TECHNICAL NOTE

Job Name: North Littlehampton
Job No: 332510715
Note No: TN004
Date: April 2022
Prepared By: Alex Wray
Subject: Response to Environment Agency Objection dated 24th January 2022

Fluvial Undefended Modelled Outlines Centered on **Black Ditch North of Littlehampton** -
Created **11/04/2016** [Ref: SSD/7430]

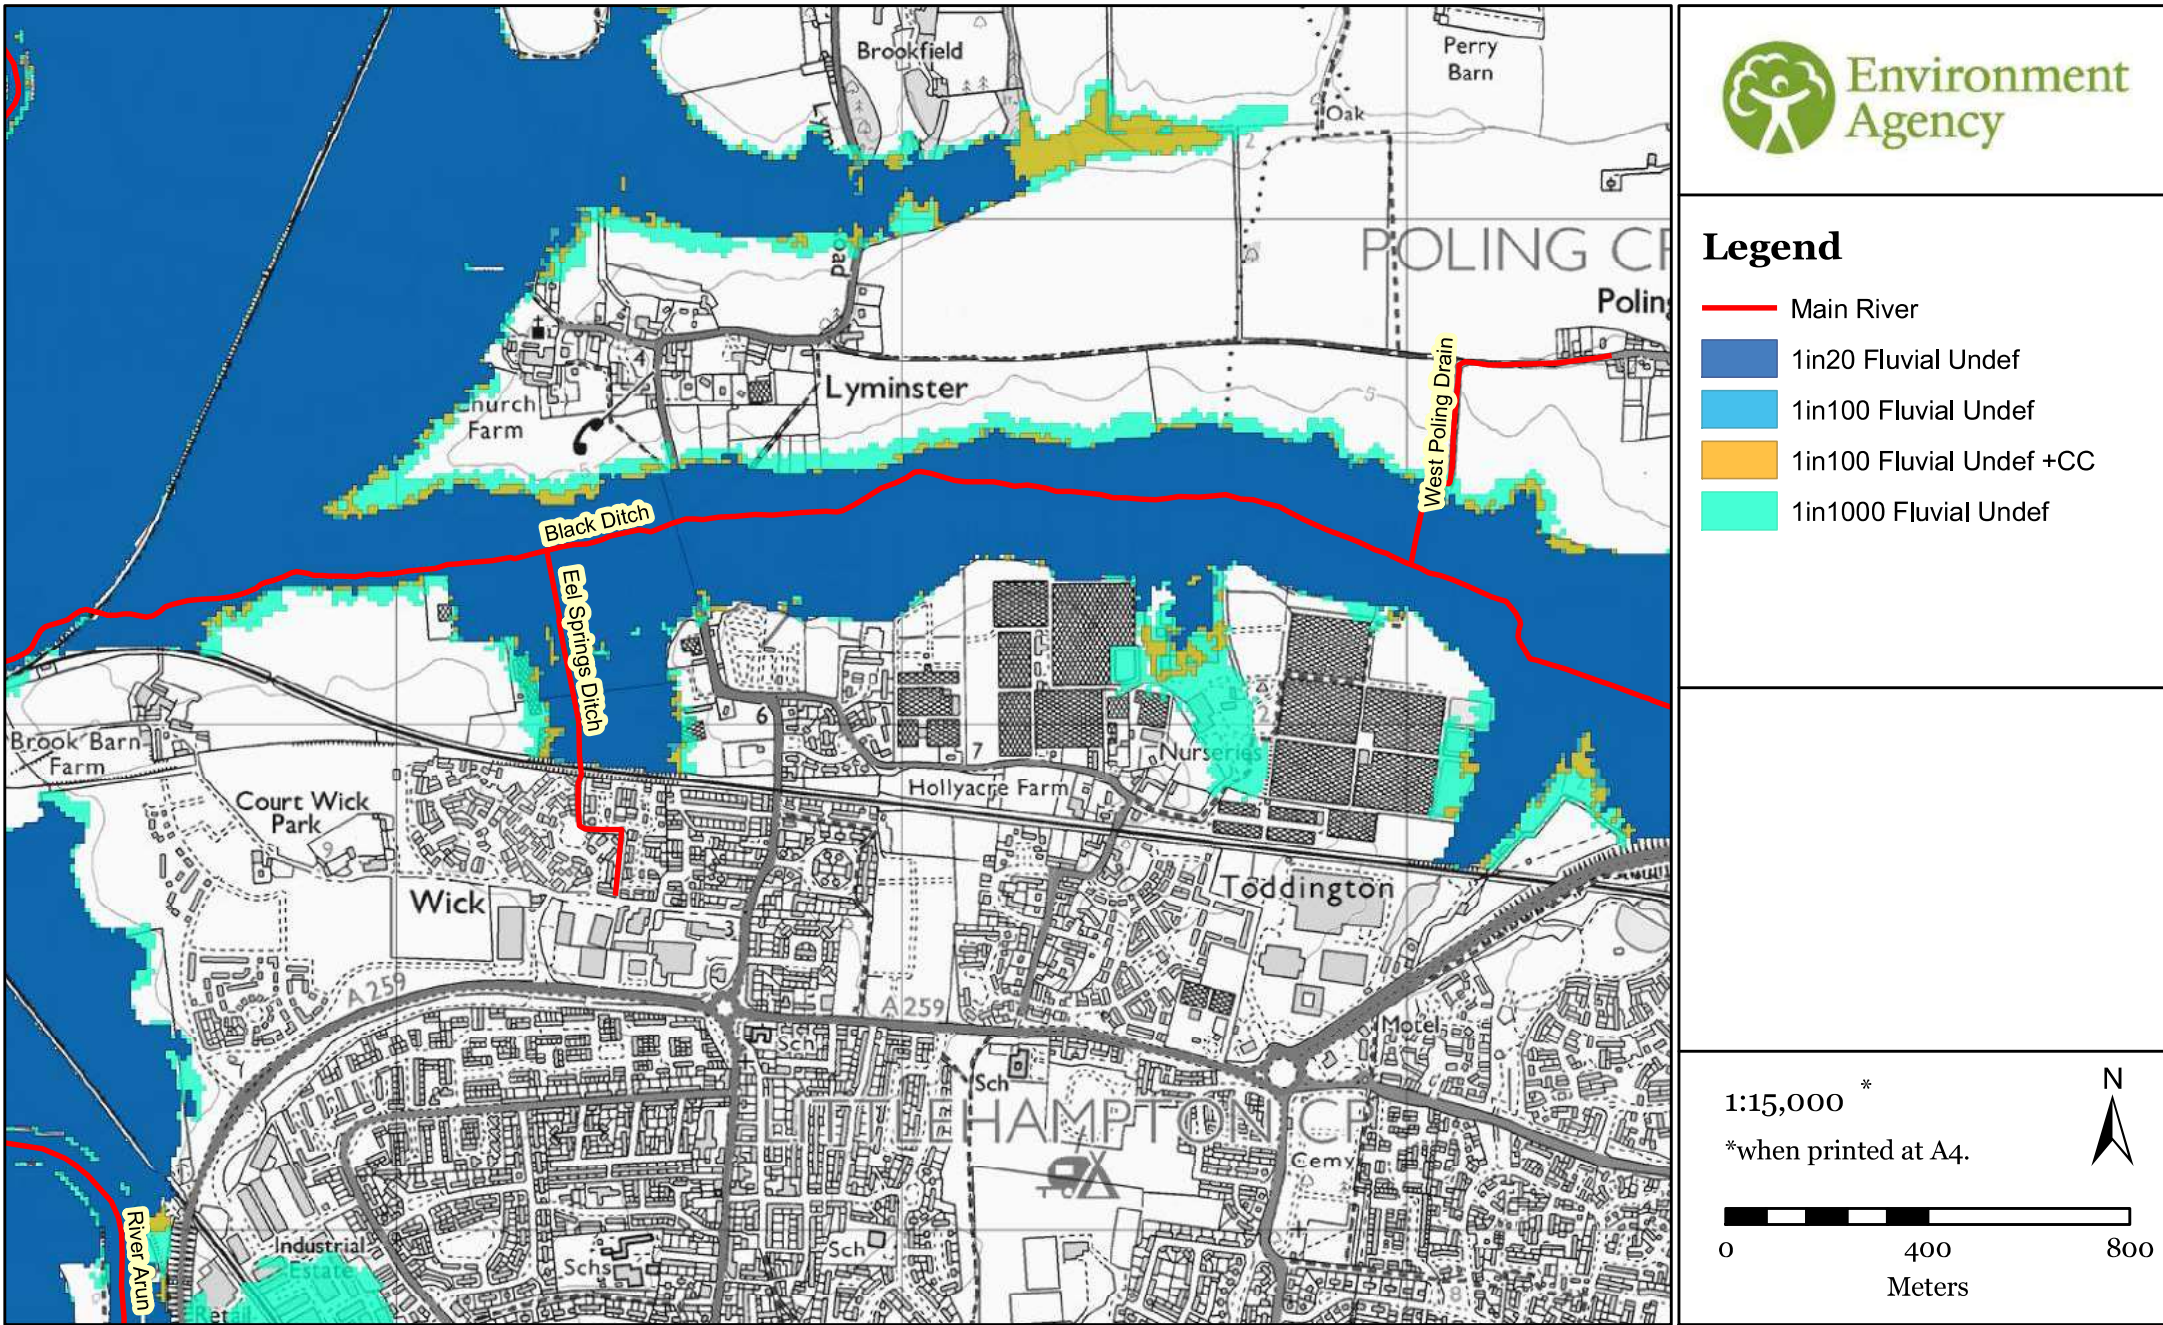
The defended 0.1% AEP flood level has been used to calculate flood plain compensation, instead of the undefended level, which is best practice; especially considering the modelling used is over 10 years old and no additional modelling has been undertaken to establish the impacts of climate change. We would therefore request to use the undefended 0.1% AEP flood level of 2.90m AOD for the flood plain compensation calculations.

It looks like the majority of the compensatory storage area is within Flood Zones 2 and 3. This is an inappropriate location for a compensatory storage area as this land would be expected to flood in the design event. Digging down into this land would not provide the designed compensation volume as the soil would be saturated and area would be expected to fill with water anyway. Compensatory storage areas should be providing flood storage outside of design flood extent.

Based on this proposed defended 1 in 1000 year flood level of 2.38mAOD is deemed to be agreed with the EA (as per the 2017 liaison) as an appropriate flood level to assess the flood compensation scheme.

The Product 4 data provided in Appendix B of TN003 extracted on 11th April 2016 shows Flood Zone 2 and 3 flooding to the playing fields, not the CWA. This has been accounted for within the calculations

Revision C Drawing No. 4001/008

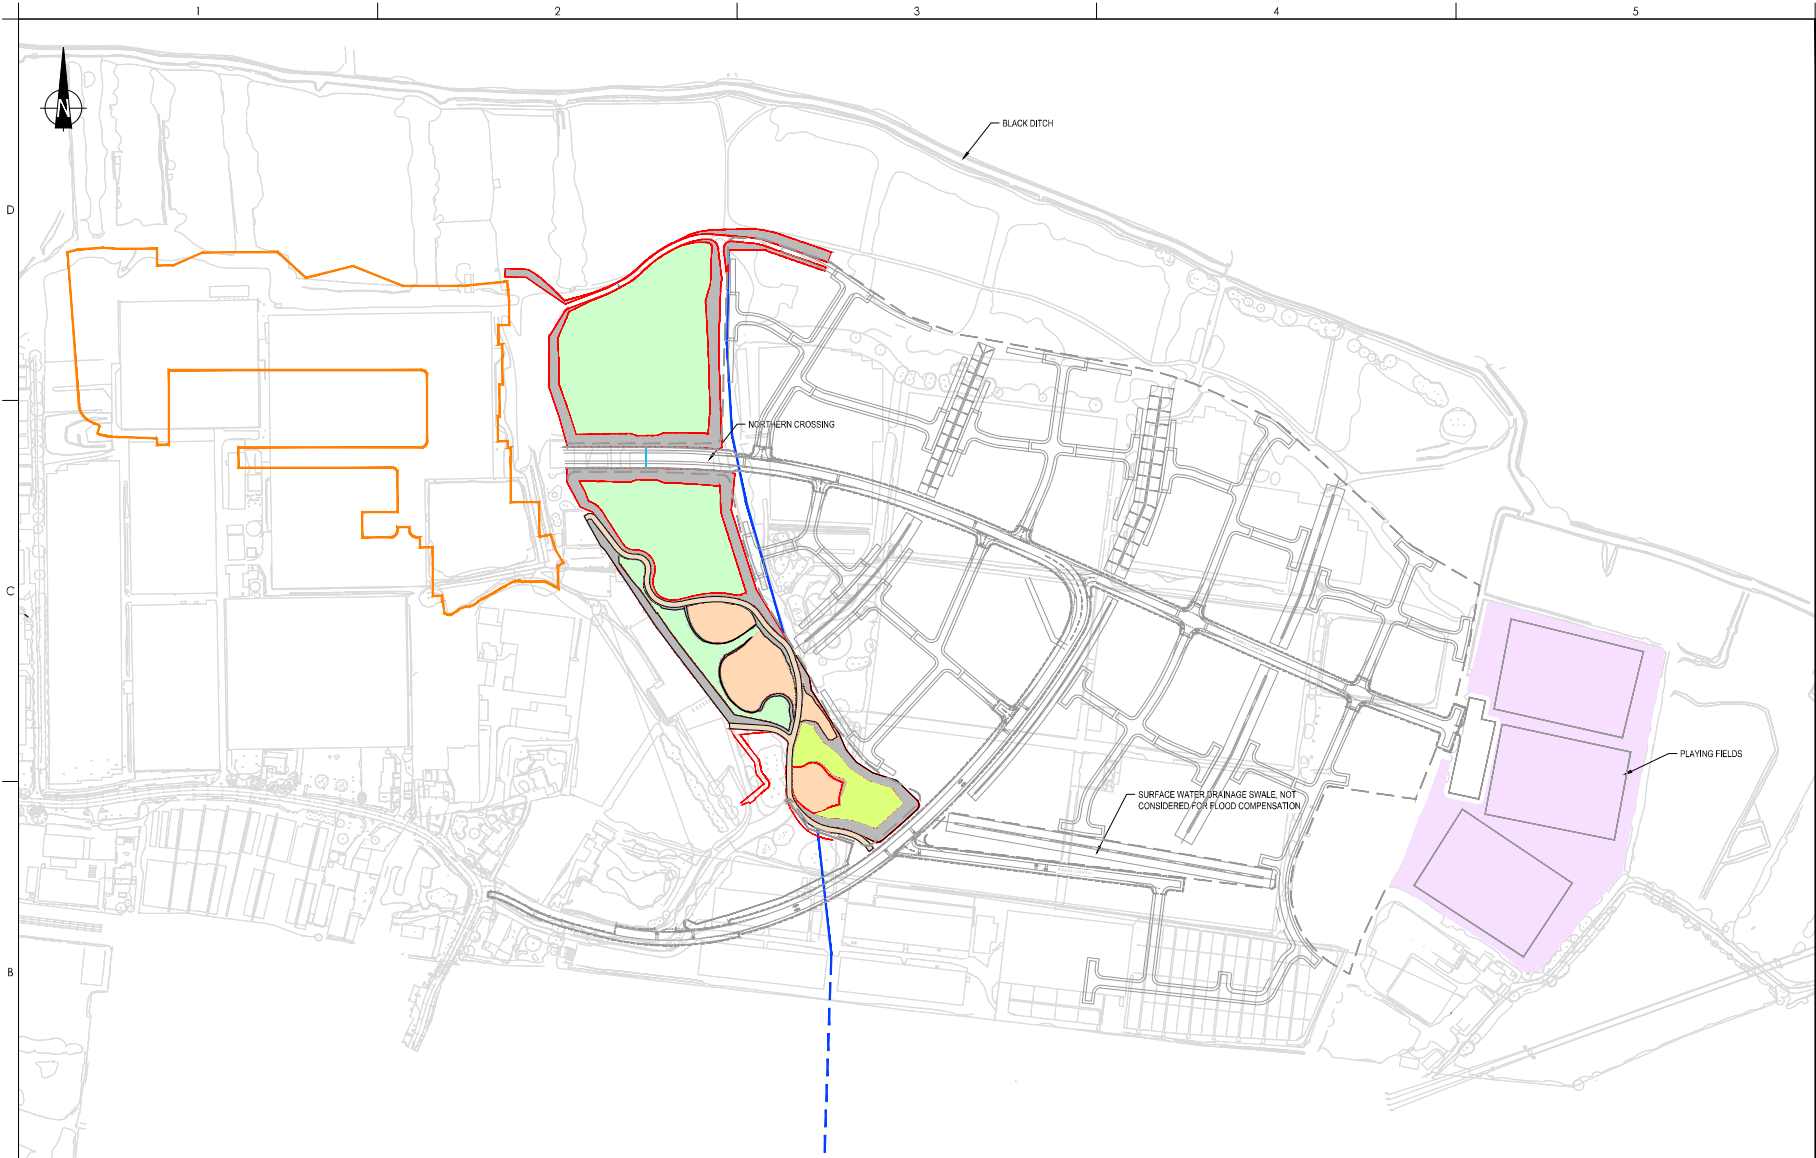
The flood plain compensation proposed with this planning application will only create 324m³ additional storage, which is considerably lower than the 27,300m³ proposed at the outline planning application, which was one of the reasons of the removal of the Environment Agency (EA) initial objection.

The calculations provided in table 1 of the Technical Note show loss of storage at the lower and higher levels. To be an acceptable compensation scheme, the volume of flood gained in each particular slice should be greater than the volume lost for that same slice.

The recent review of the latest proposals has allowed the refinement of the analysis to include the final CWA form, including the free-flowing low-level drainage ditches. This analysis also identified that there were minor corrections to be made to the triangulation of the ground model. The result of this has now been included in the table below as well as on our revised drawing 39878/4001/008 Rev. D and identifies modifications at all bands.

As a result of the update, the current design shows significant overall gains in storage of 8193m³ across the site, which is closer to the original FRA figure.

Following the review of the ground model and proposals outlined in our response to point 2 above, the level-for-level losses at the low levels have been updated. With regards to the principal concern at the lower levels, the revised analysis shows gains in the lowest bands with a small loss within a single band. Table 2 below shows the cumulative flood storage for all bands as a result of the flood compensation, demonstrating positive storage throughout.

ELEVATION SINGLE SPAN

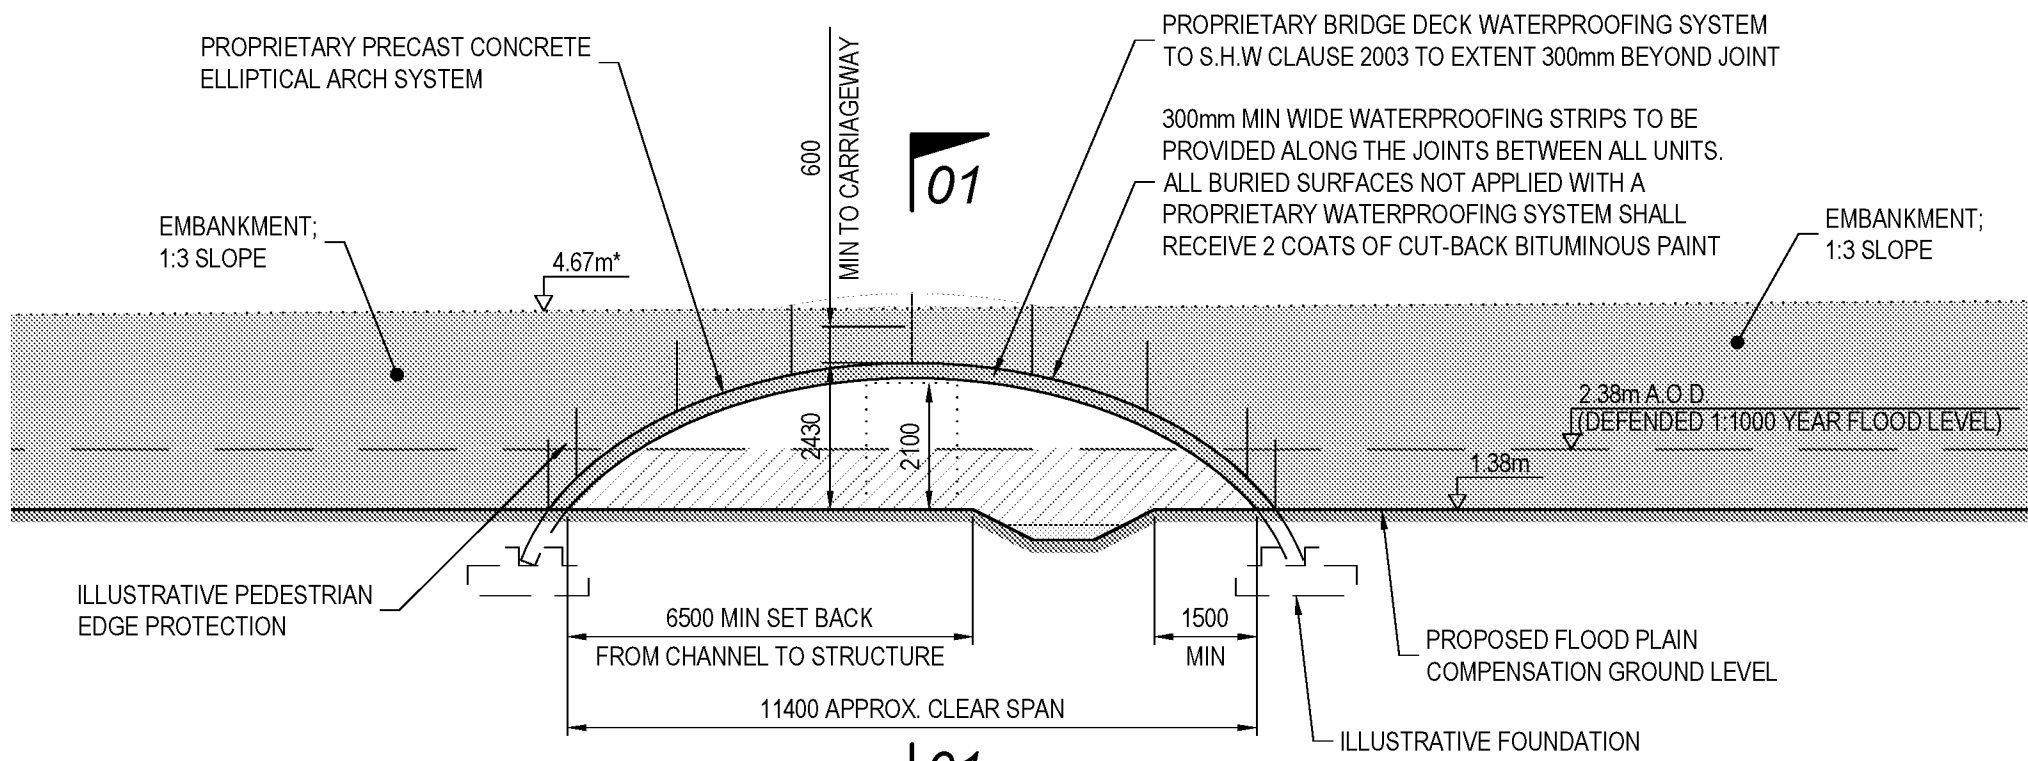
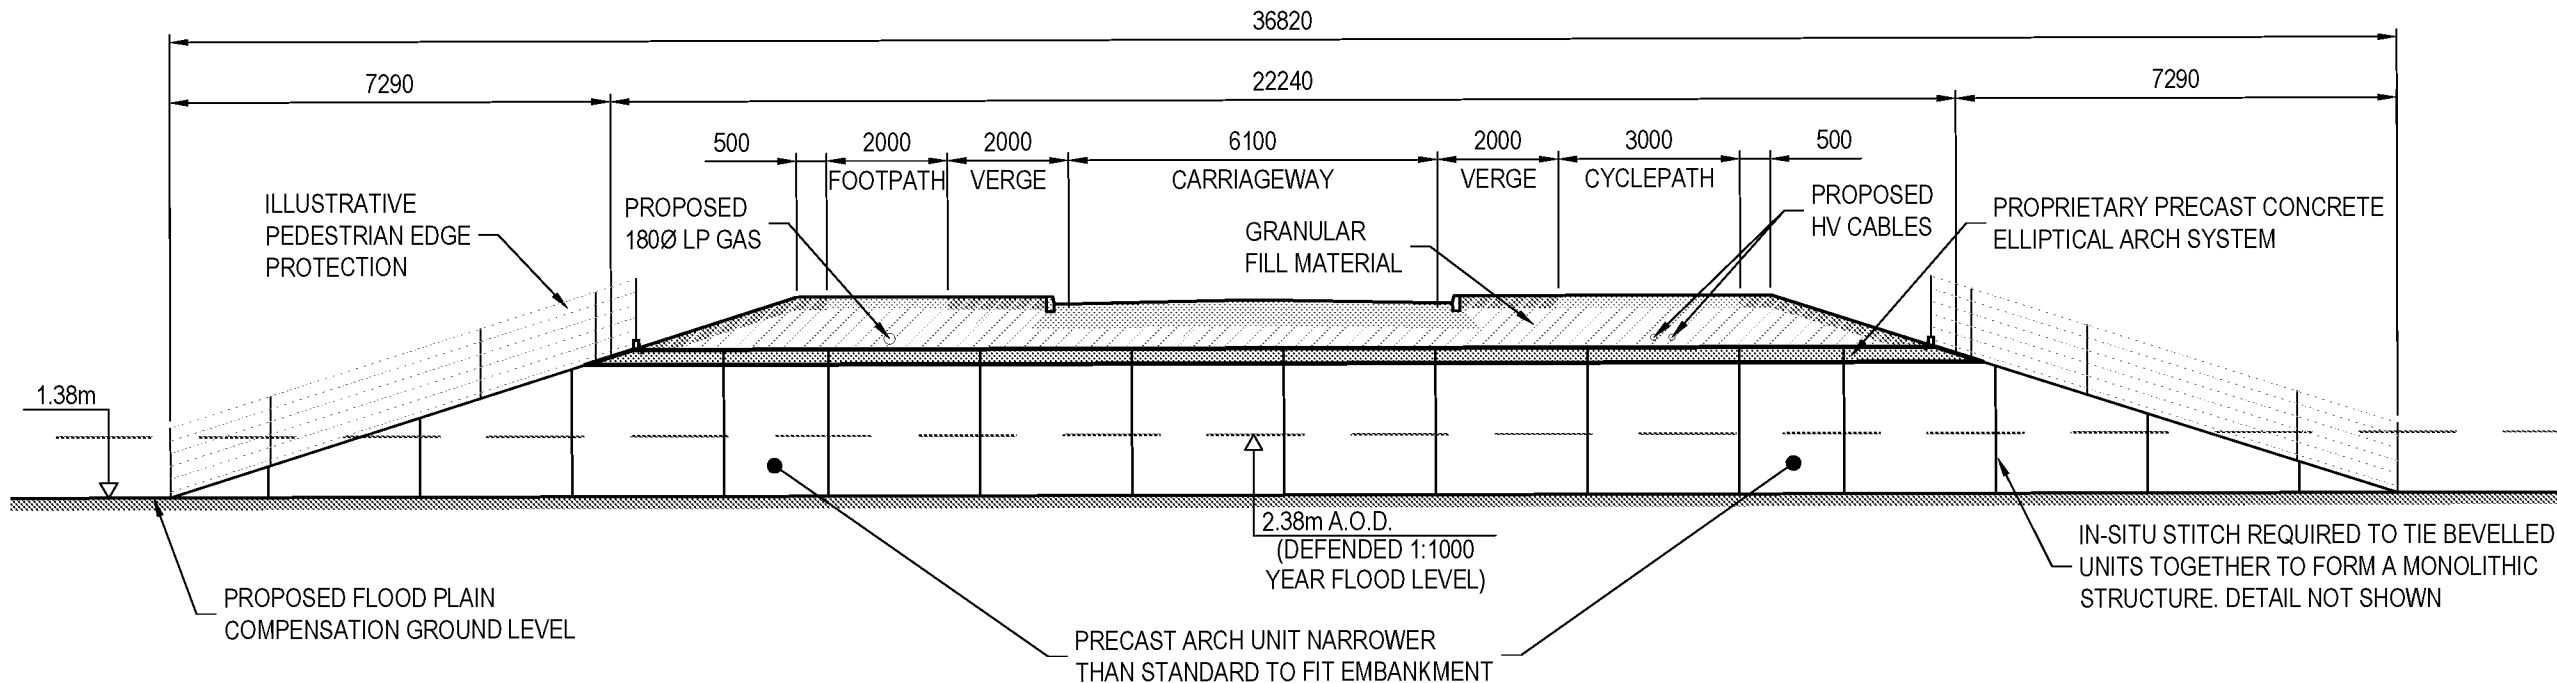
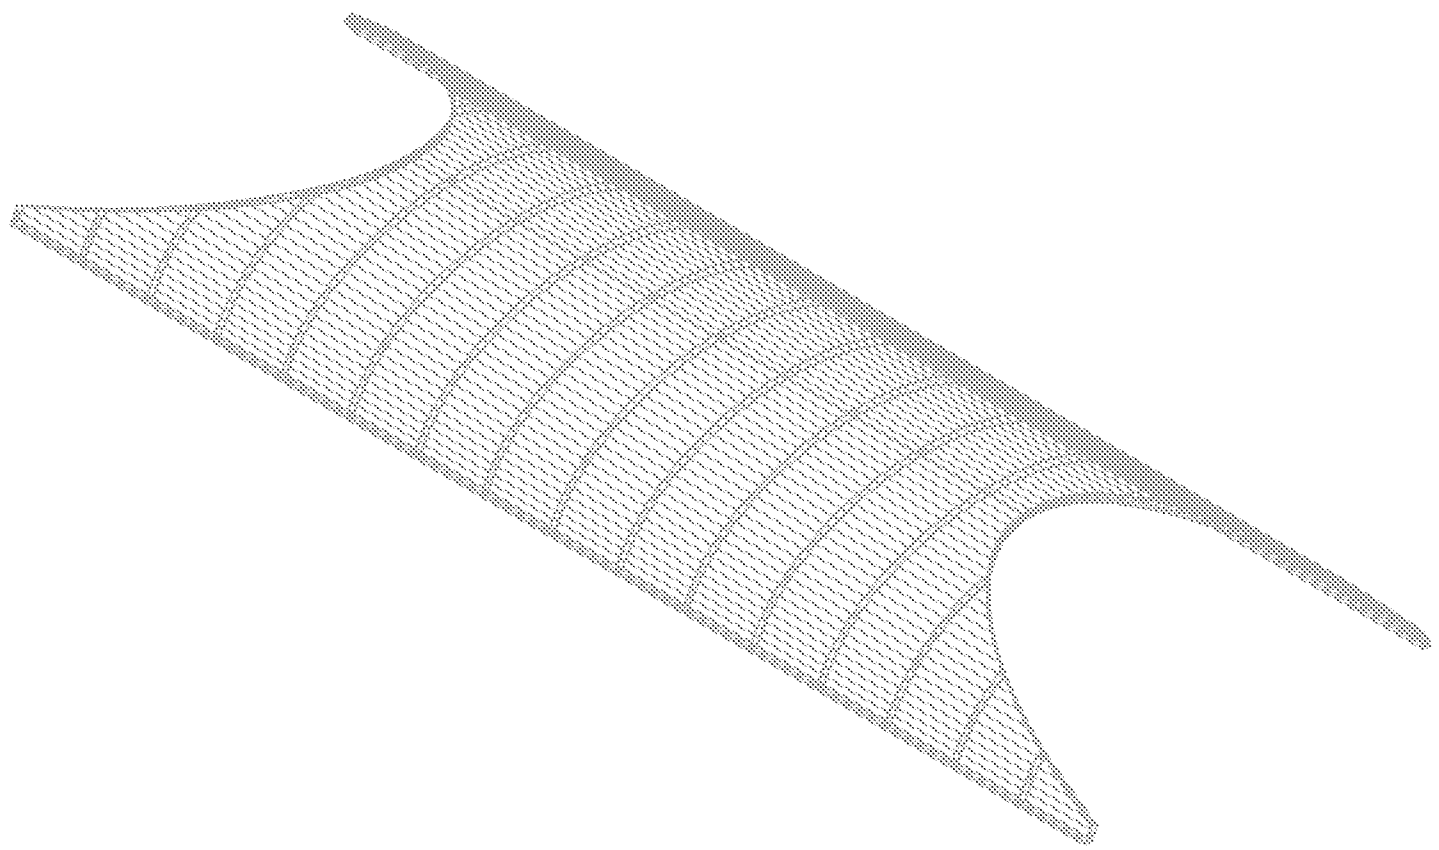
Unsatisfactory information in regard to the watercourse crossings have been submitted.

In our previous responses we stated that the EA will always request road crossings to be of a clear span variety, for the purposes of flood flow. Also, the soffit level should be set at least 600mm above the undefended 1% AEP plus the appropriate allowance for climate change. In this case it appears that defended levels have been considered. Furthermore, culvers have been proposed as a means of crossing for the footpaths which are against EA policy. It'll also be useful if evidence of discussions about the arch crossing can be provided to confirm this was agreed as an appropriate means of crossing.

Within EA permitting for clear span bridges they define a clear span bridge as 'a clear span bridge, being a bridge that requires no bed or bank reinforcement and no support in the watercourse'. We would argue that the precast arch solution proposed meets this description

Drawing 39878_4001_001B provided in Appendix B of TN003 shows the soffit of the road crossing is currently shown 1100mm above the defended 0.1% AEP flood level (2.38m AOD). If the modelled undefended 1% + CC level (2.47m AOD) was used then this reduces to 1010mm.
